M5 Junction 10 Improvement Scheme (Ref: TR010063)
ISH4 Submission
Property at [REDACTED]

19th September 2024

Drawing Title
TYPICAL DETAIL ENVIRONMENTAL BARRIER REGULATION 5(2)(o) & 6(2) SHEET 01 OF 01

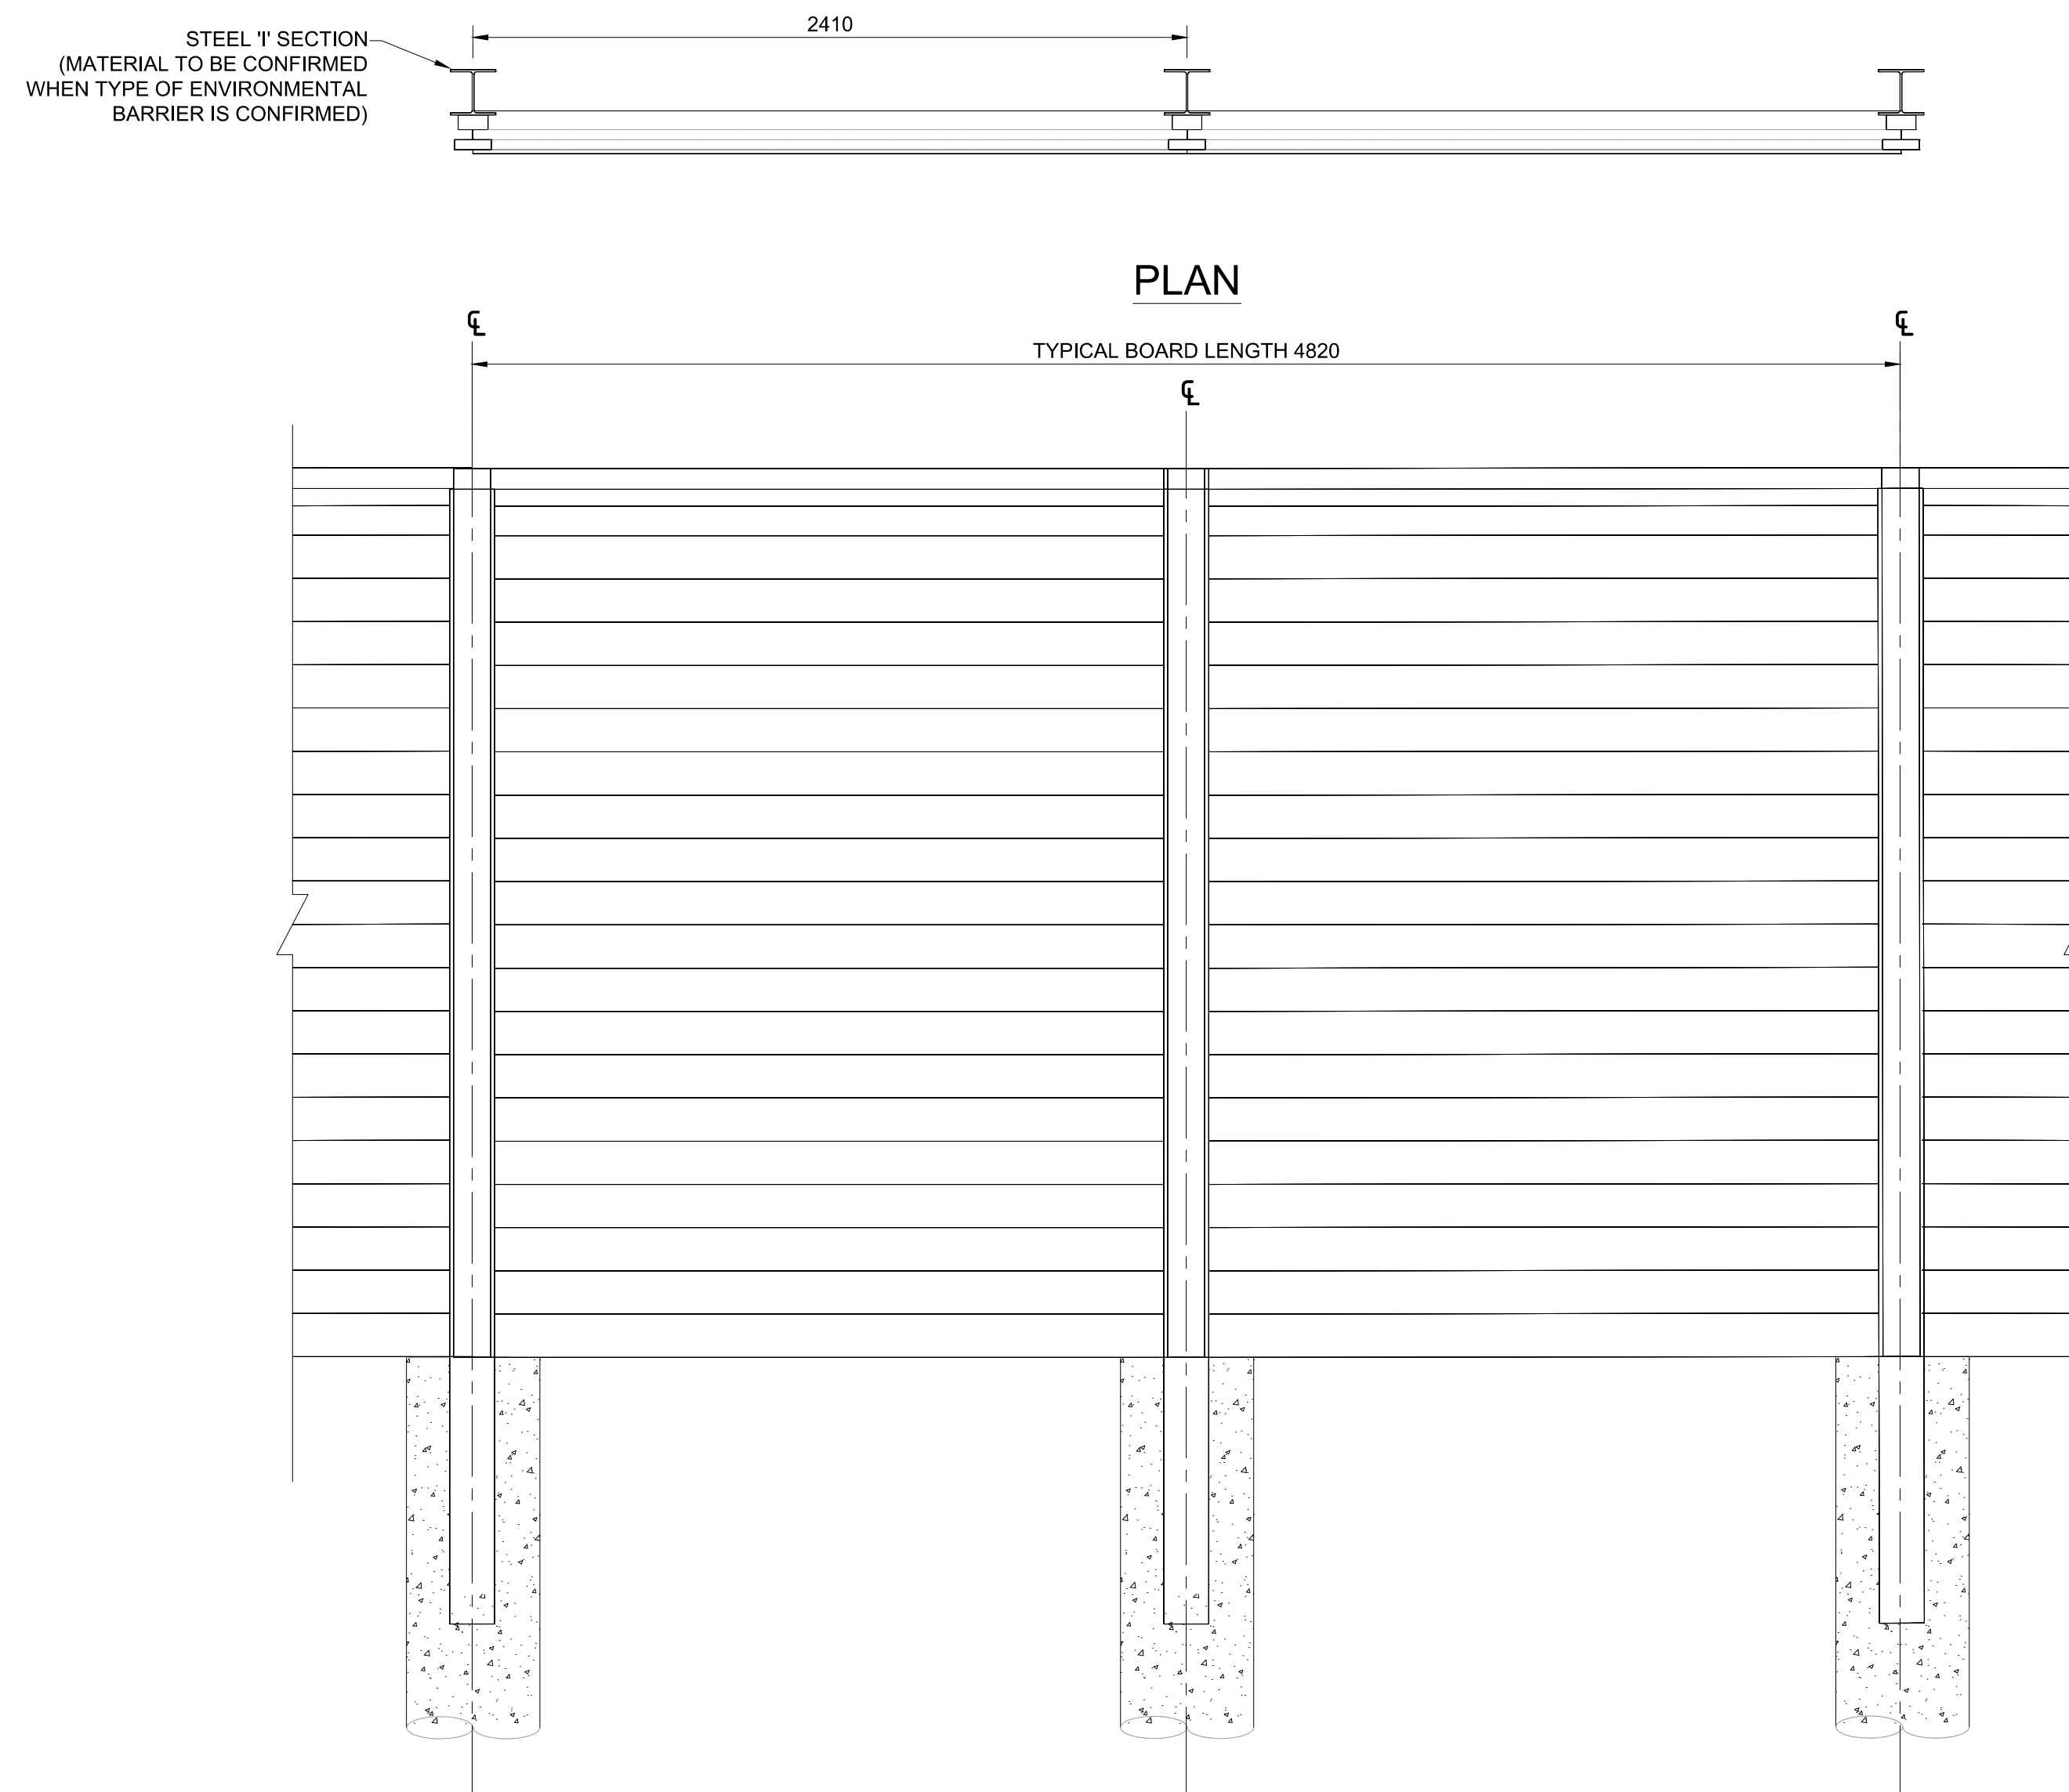
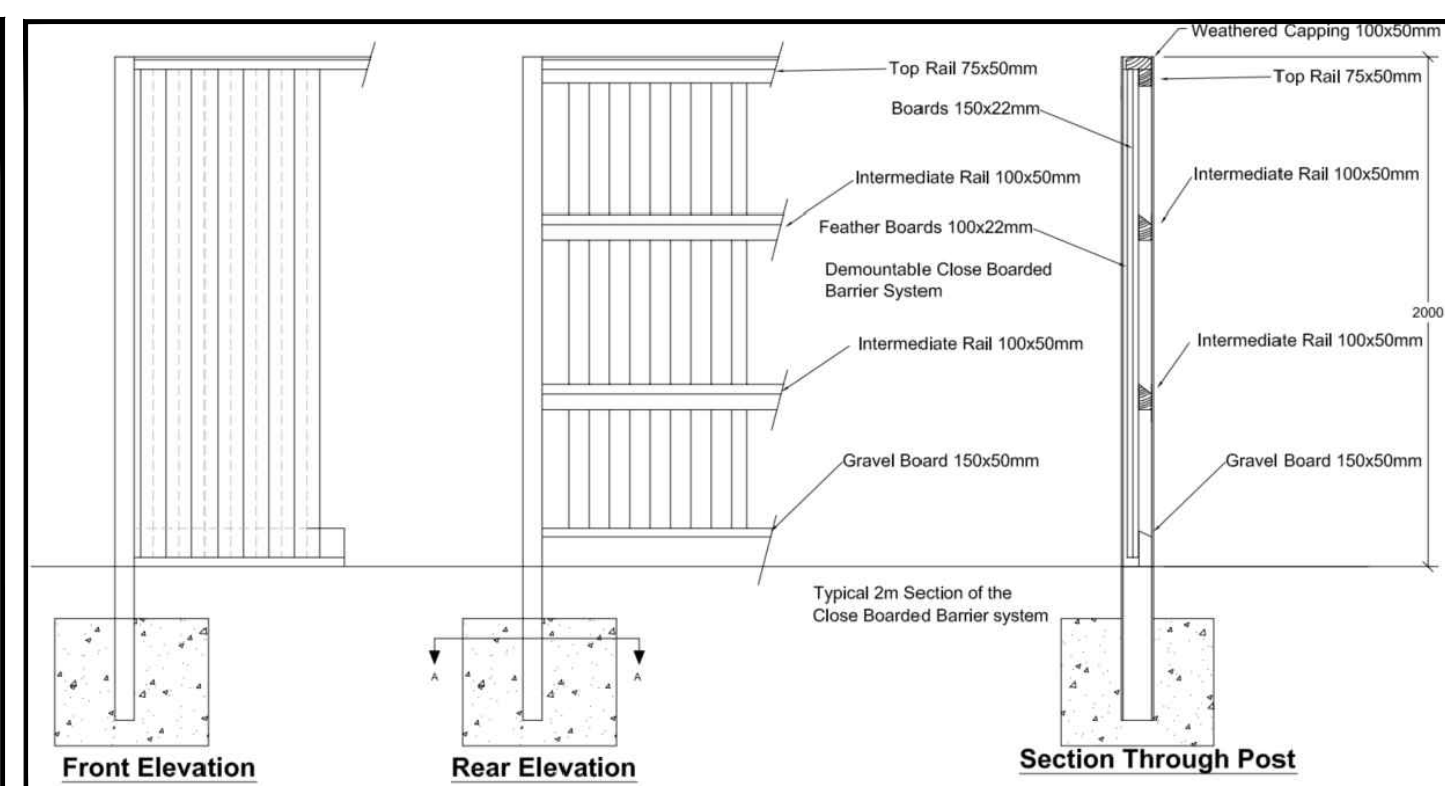
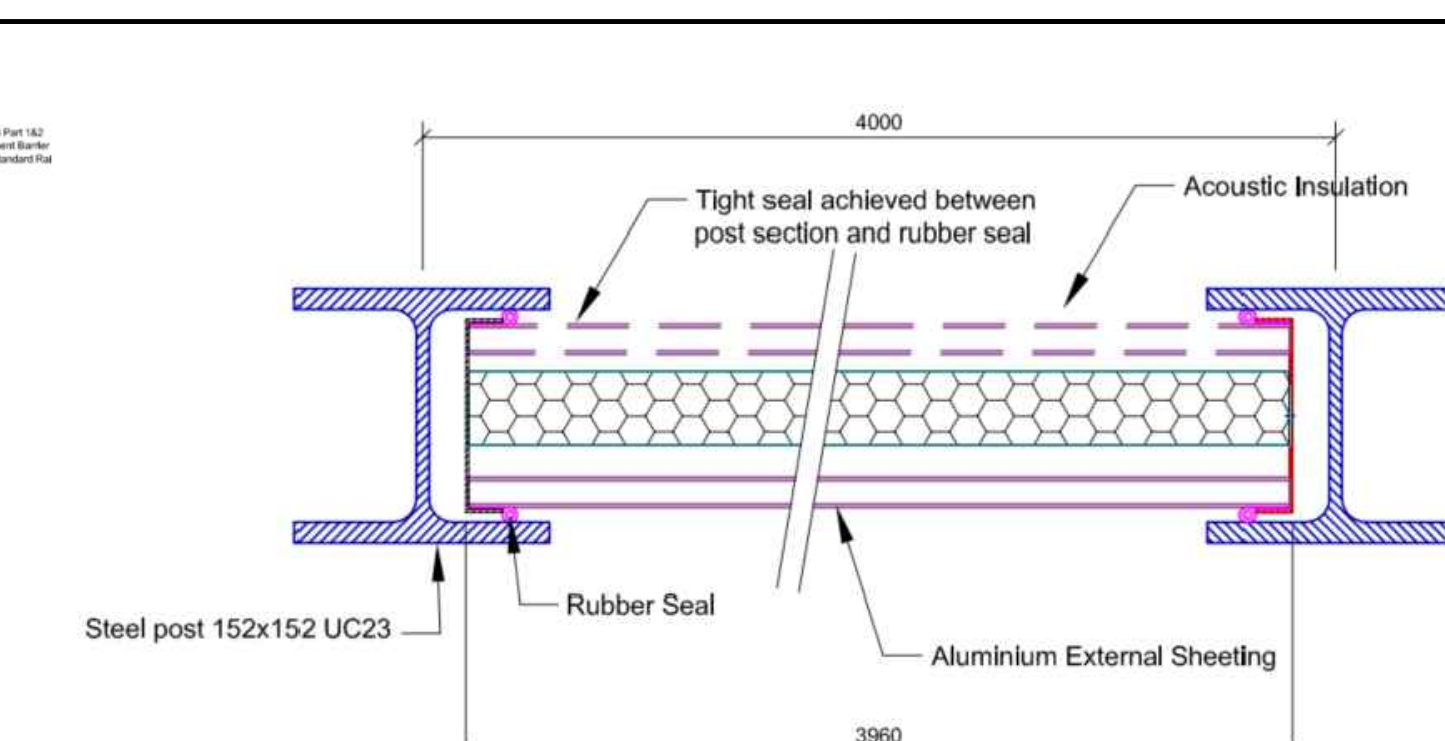
As to the Landscape and Visual aspect the Applicant's response appears to assume that the barriers will comprise a 2 metre high barrier of non-specified material that could be a simple timber board design and that a vegetated solution is not required. However, it goes on to say that should a vegetated design be identified as the preferred option from the consultation undertaken at detailed design stage, space for such planting could be then considered.

I have to say I find this very confusing and, indeed, the response of the Joint Councils is that there appears to be some ambiguity in this regard, where they acknowledge that the Landscape and Visual Impact Assessment assumes an enhancement to a standard plain barrier, but also say at the current preliminary design stage the proposal is for a timber acoustic fence.

With respect, I consider, as the landowner affected, I am entitled to certainty at this stage, by way of an upgraded version of acoustic barrier, because I do not consider the basic version would provide the mitigation expected and to which I am entitled. My view appears to be confirmed by the assessment of 'Slight Adverse' in Year 1 and again 'Slight Adverse' in Year 15, but that the key aspect of this is the proposed lighting columns. My reaction to this is that it is simply not good enough and further I would strongly object to lighting columns being located directly outside the property as I find it difficult to see any reason why they could not be located otherwise.

As to the Noise aspect, in the Applicant's response, I note the reference to the importance of reducing noise impact. Again, my position is that I consider I am entitled to an upgraded version of acoustic barrier as I have my doubts that the

basic version would provide the necessary protection and mitigation. I have to say that I am not clear as to the Meaning of the statement that 'the noise barrier contributes 5dB improvement (Moderate in Future Year), leading to a combined noise reduction of up to 10dB (Major in Future Year) for the Scheme overall'.

As I mentioned at the preliminary meeting I have major concerns that the acoustic barrier, as currently indicated, terminates some distance prior to the Eastern boundary of the Elton Lawn property. I find this unacceptable and inconsiderate. As well as failing to provide any protection for a large part of the garden, noise generated East of the current termination point would inevitably impact on the property. As I also mentioned at the preliminary meeting, road noise generated from a single modest sized vehicle travelling at a modest speed is of itself significant and the extent to which this is compounded by large volumes of vehicles and HGVs of various description is the reality one is faced with. I, therefore, again request that serious consideration is given to the extension of the currently proposed Eastern termination point so that the appropriate and necessary protection and mitigation can be provided. I would appreciate some dialogue and a site meeting with the Applicant's noise specialists involved to address and take this issue forward.

I, therefore, respectfully request that the actual design, specification and quality of the acoustic barriers, both as to the Landscape and Visual and Noise aspects take my comments into full account.
